Our Ref: DOC19/782608

RE: Environmental Impact Statement - Coffs Harbour Bypass (SSI 7666)

30 October 2019

Figure 2.1: Location of Rusty Plum records in the Coffs Harbour Bypass alignment.

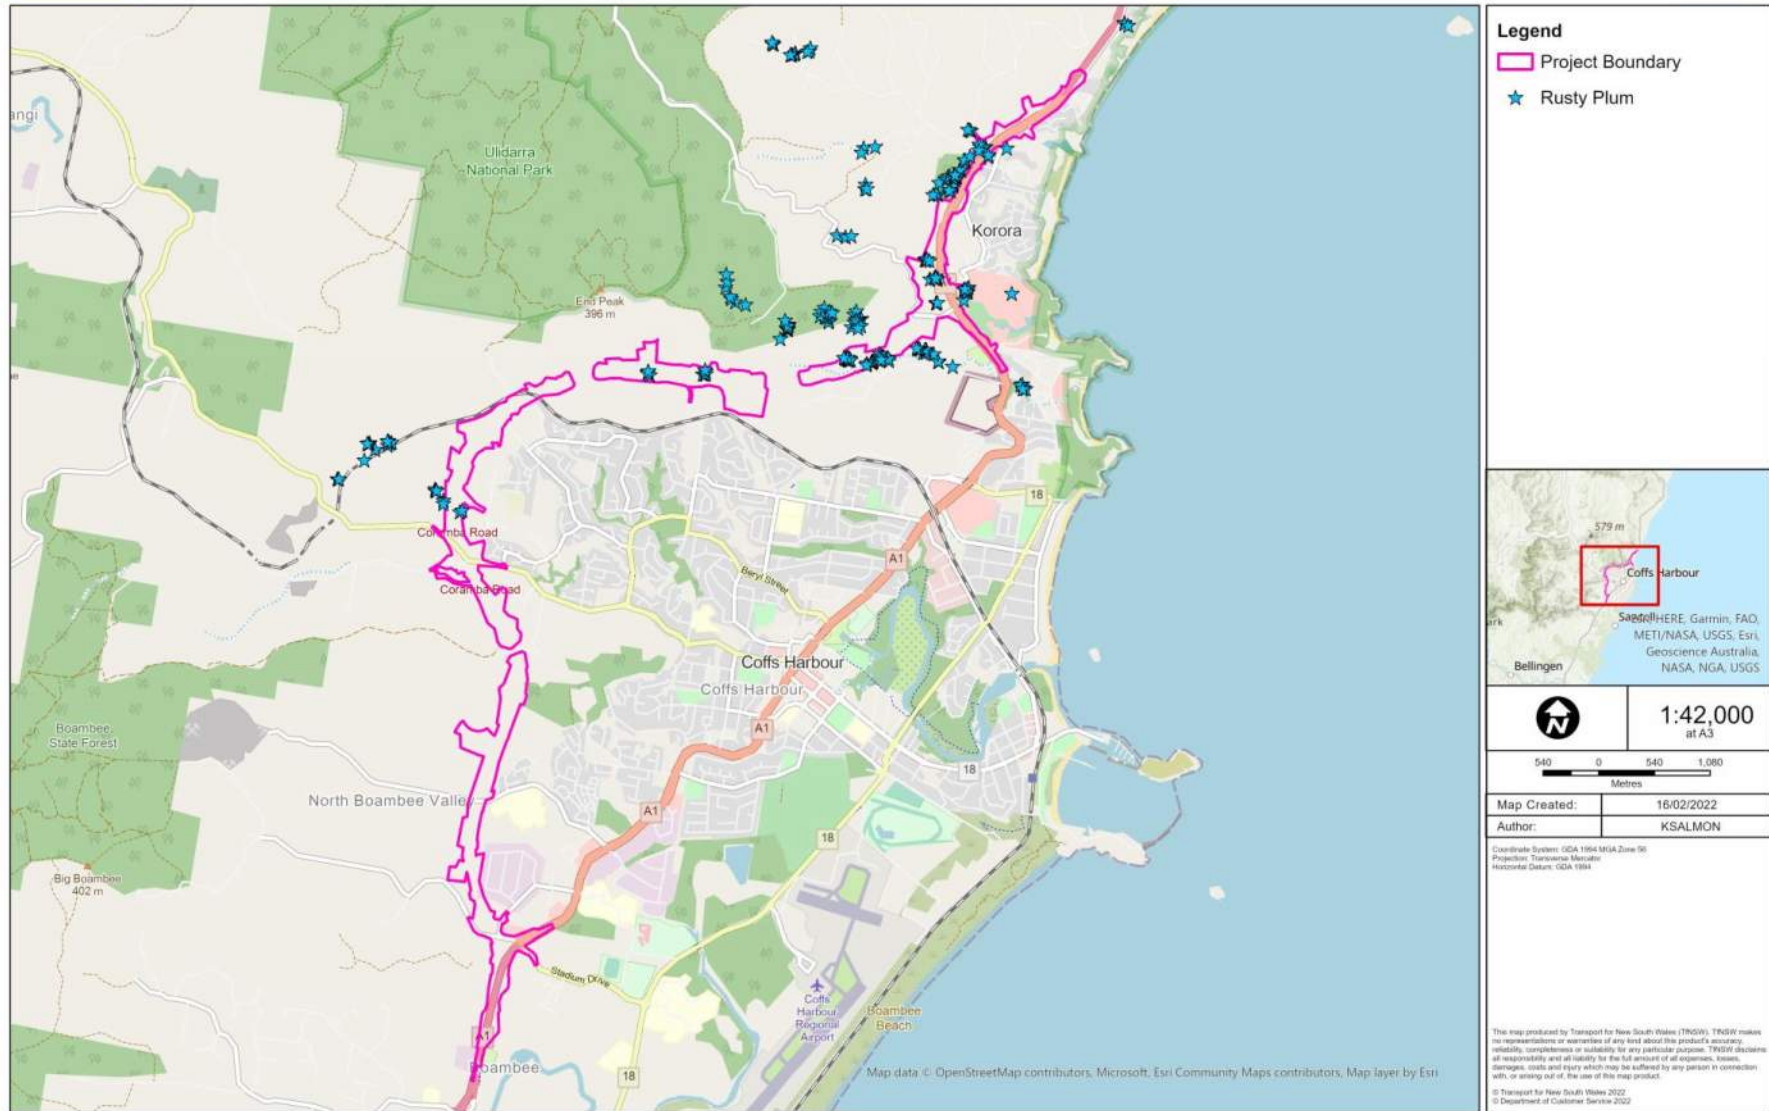
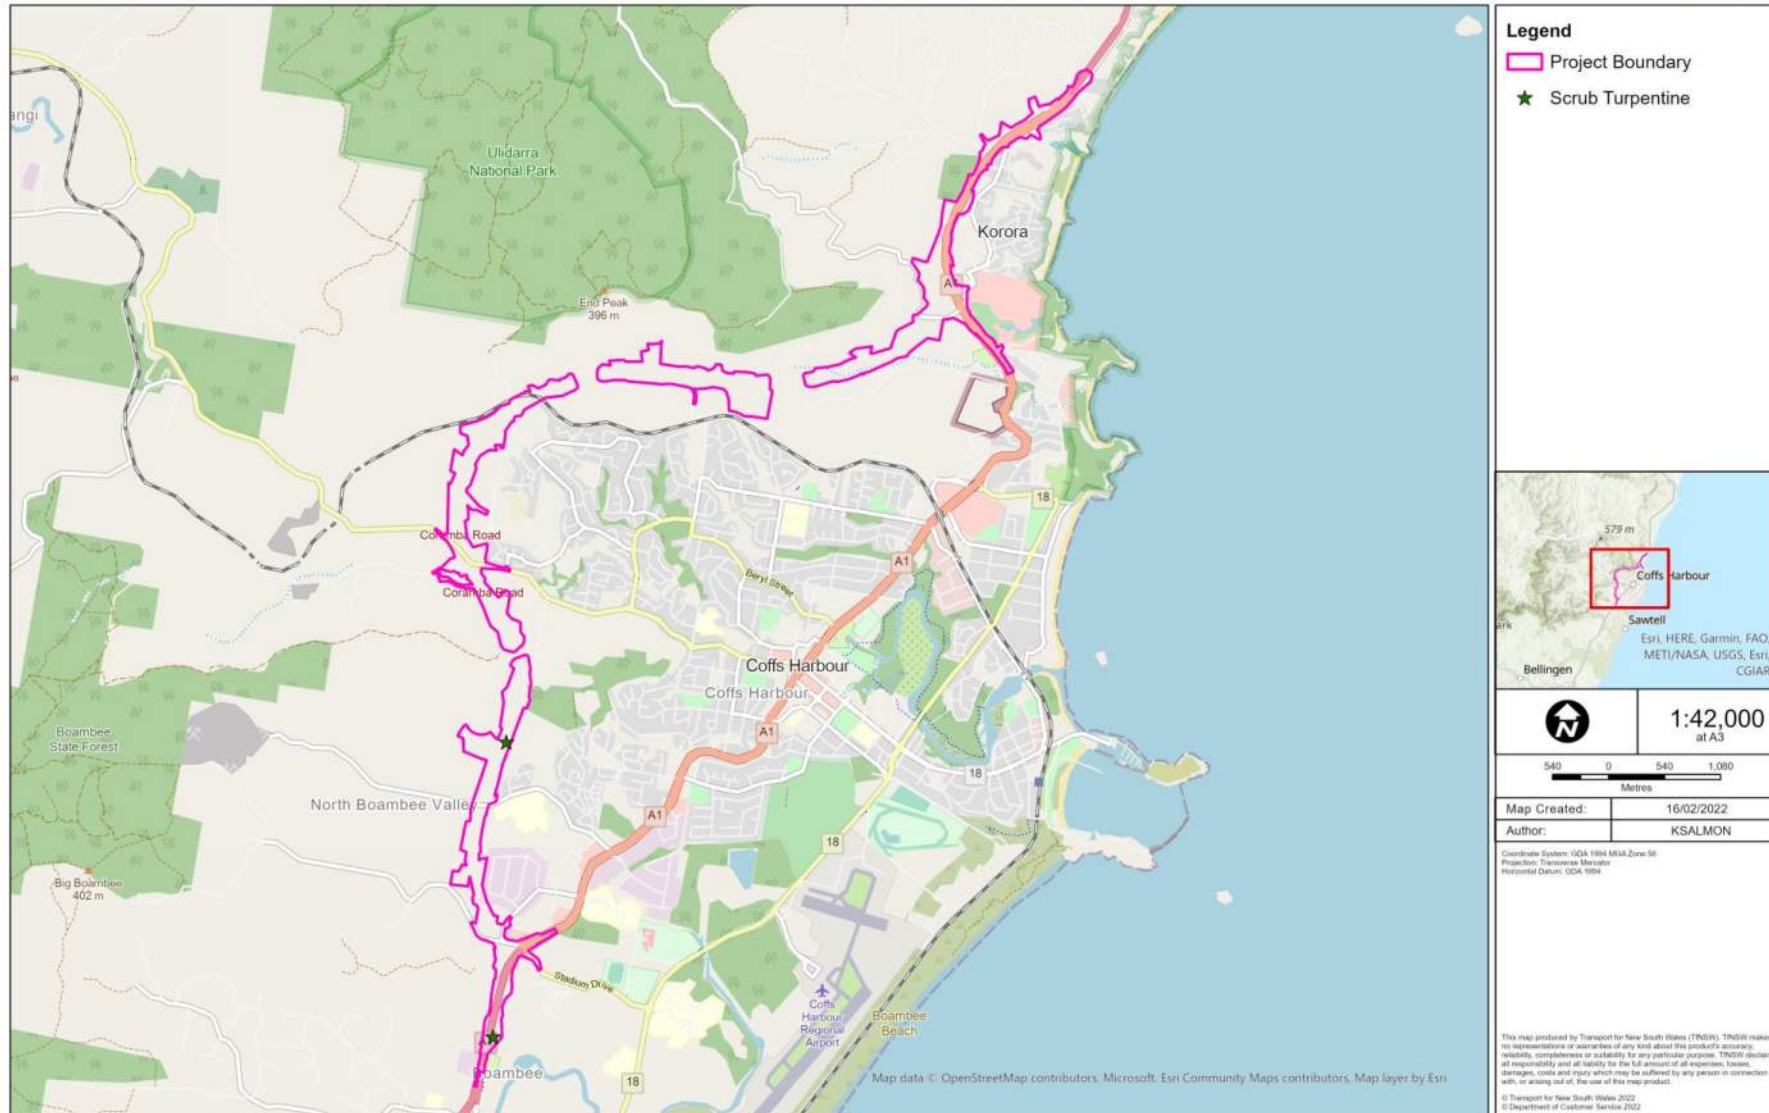
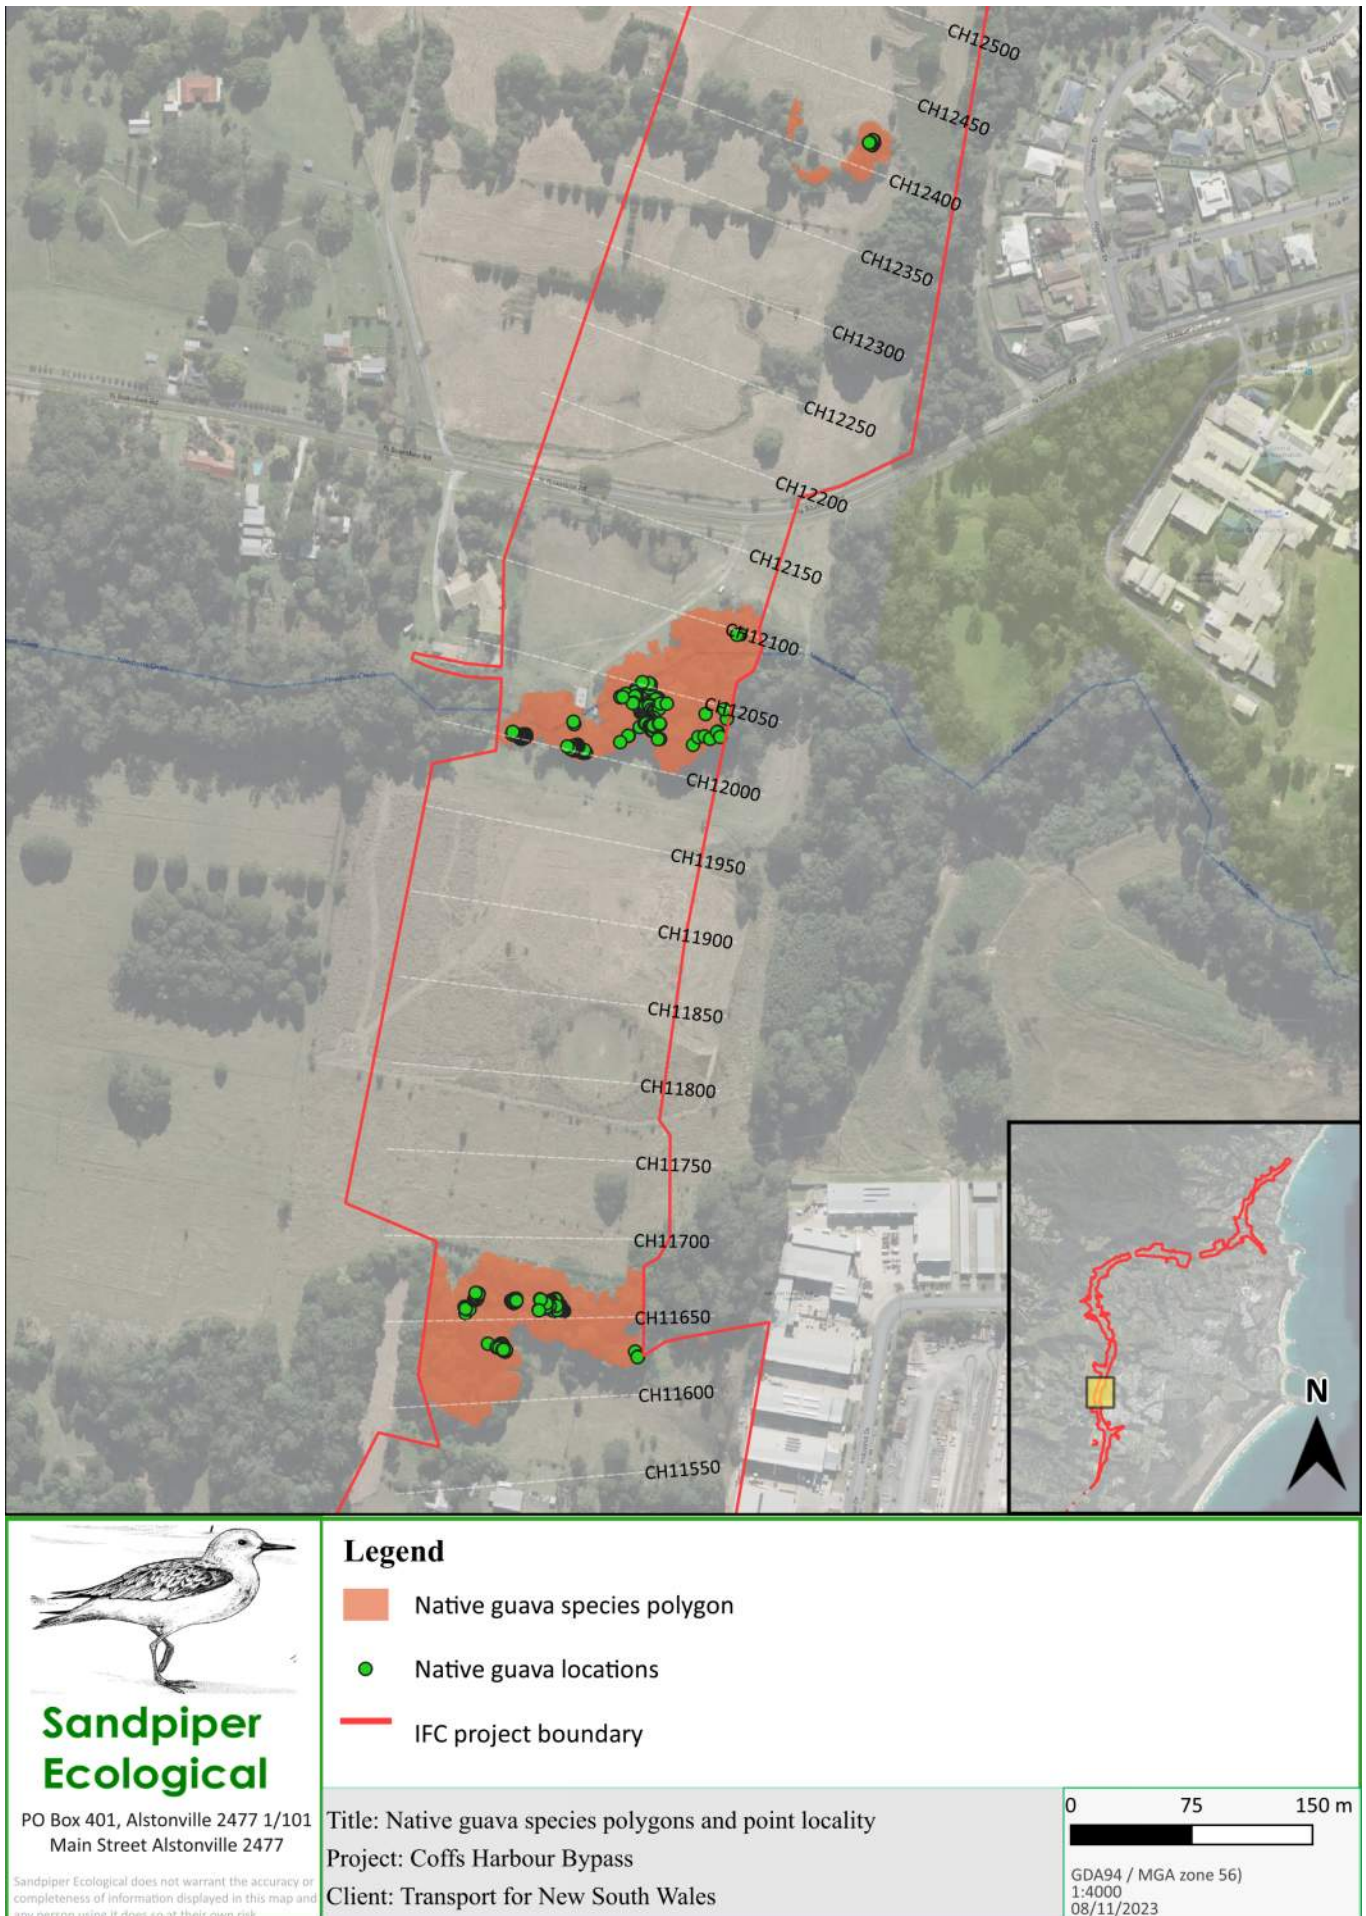
We also note that the list of flora recorded on site and documented in Appendix 1 of the BAR indicates that the critically endangered scrub turpentine (*Rhodamnia rubescens*) was recorded in three sampling plots across the development site (plots 17, 29 and 36).

12. Given the recording of this critically endangered species, the scrub turpentine must be assessed further to determine the extent of this species across the development site, where suitable habitat exists. This assessment can be undertaken by either assuming the species is present, undertaking a targeted survey, or by obtaining an expert report.
